Our ref: OUT22/5883

Subject: Gazcorp Industrial Estate Modification 2 (SSD-5248 MOD 2)- Modification Report and DHL Warehouse and Distribution Centre (SSD-36156297)-(EIS)

The proposed modification seeks consent for a concurrent modification to the Gazcorp Industrial Estate development to reflect a revised layout of the proposed DHL warehouse and distribution centre. The DHL Warehouse and Distribution Centre project is a proposed construction and operation of a new warehouse and distribution centre with approximately 29,710 m2 of industrial warehouse floorspace.

TAIL-OUT DRAIN LONG-SECTION

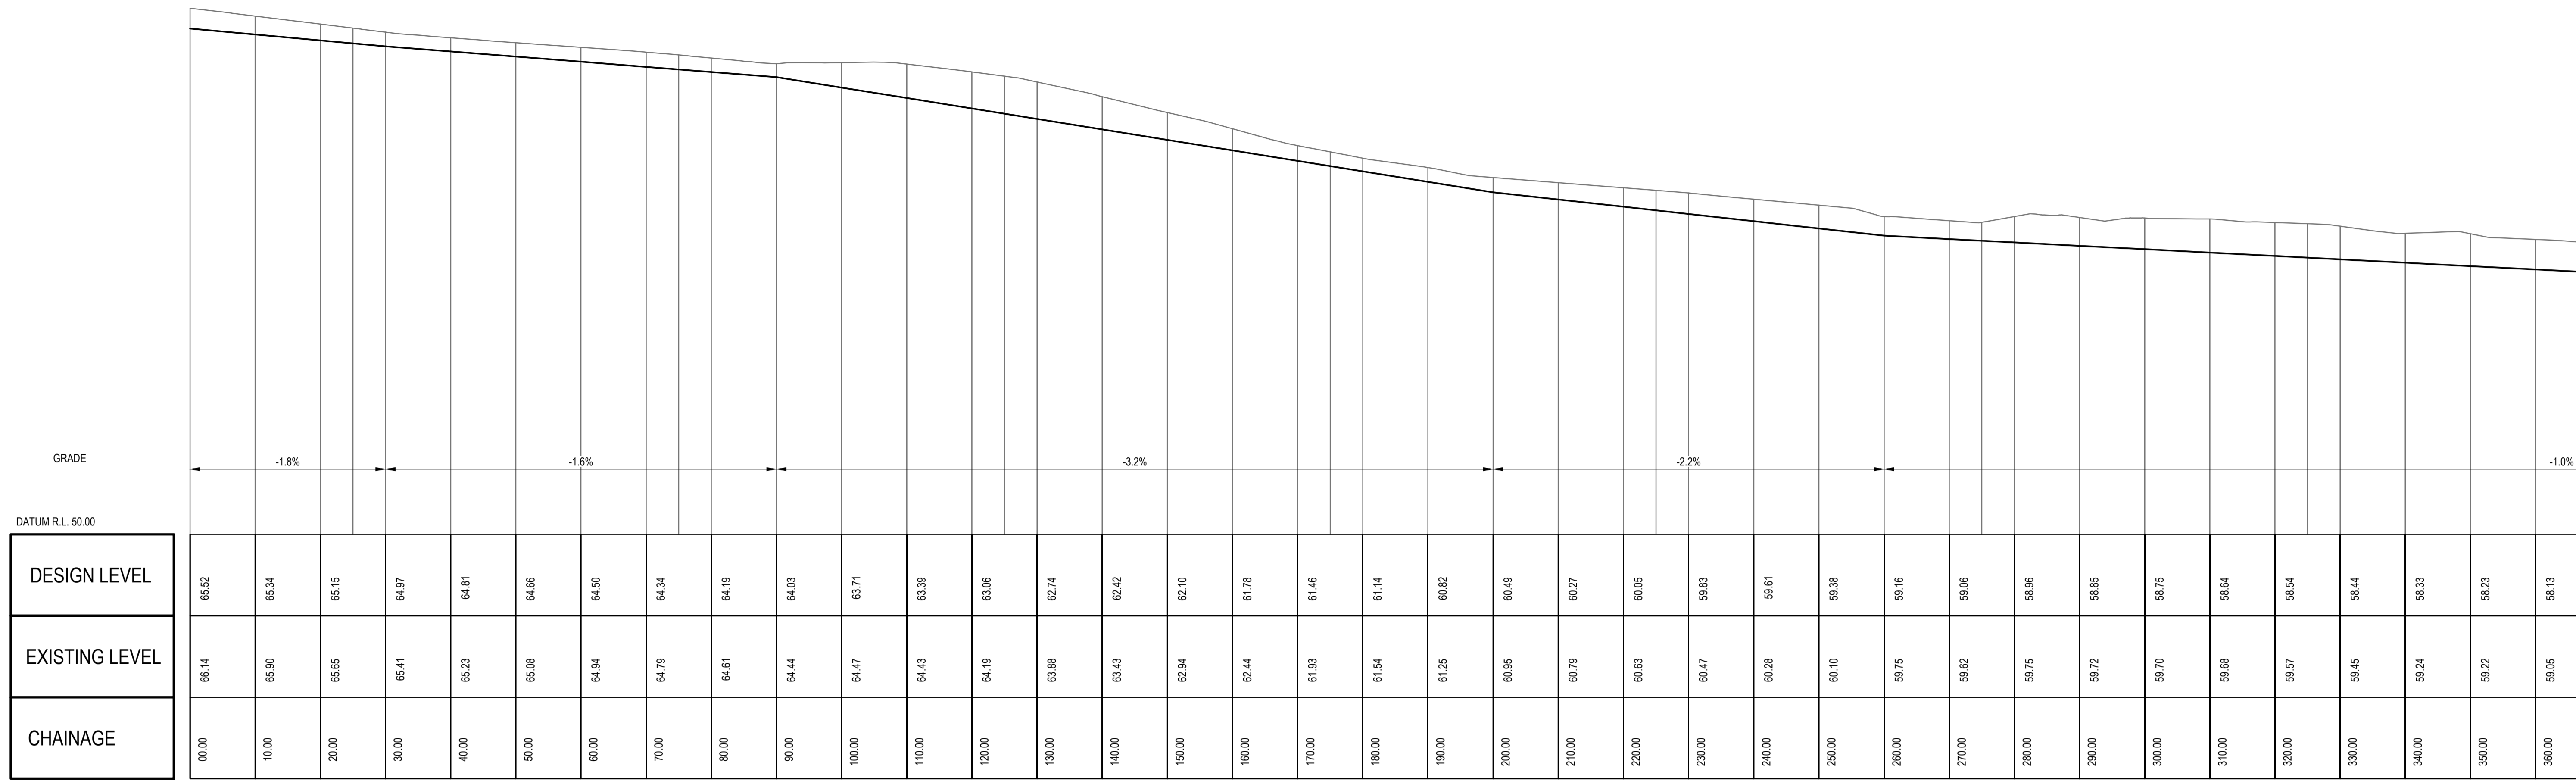
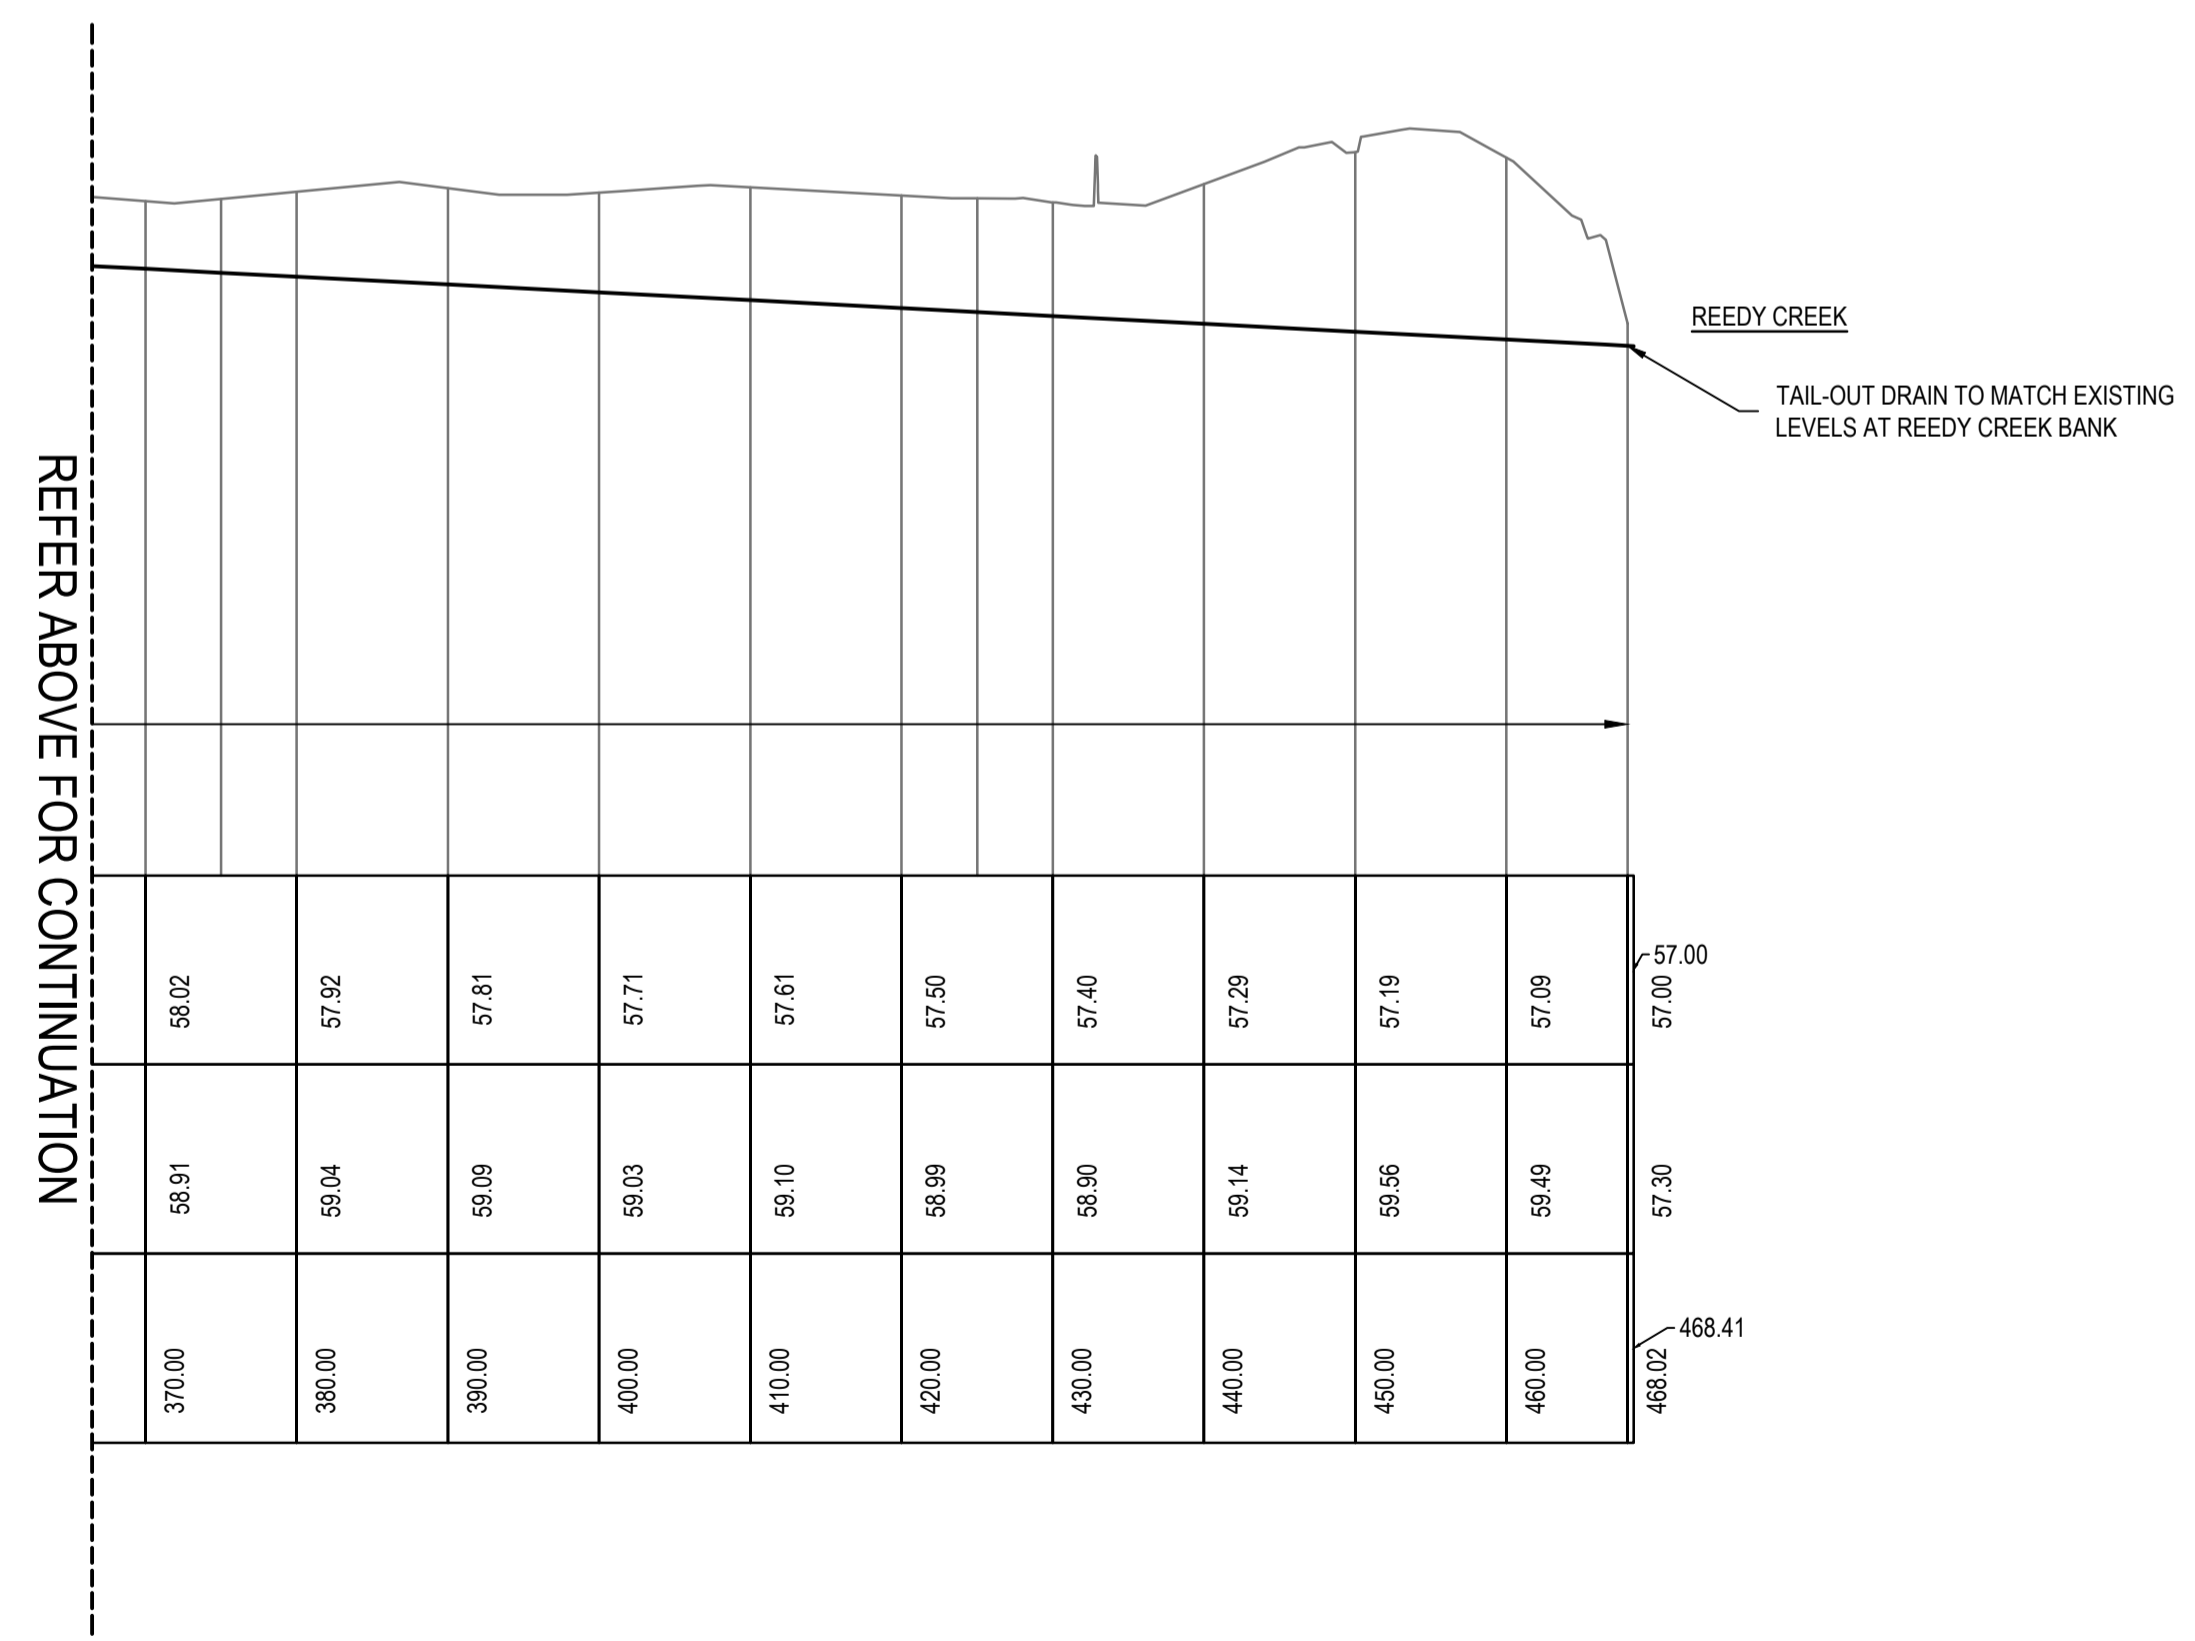
- Works within waterfront land need to be in accordance with the Guidelines for Controlled Activities on Waterfront Land.

All works within waterfront land should be in accordance with the Guidelines for Controlled Activities. This includes the drain outlet into Reedy Creek. The Guidelines can be found at: <https://water.dpie.nsw.gov.au/licensing-and-trade/approvals/controlled-activityapprovals/what/guidelines>
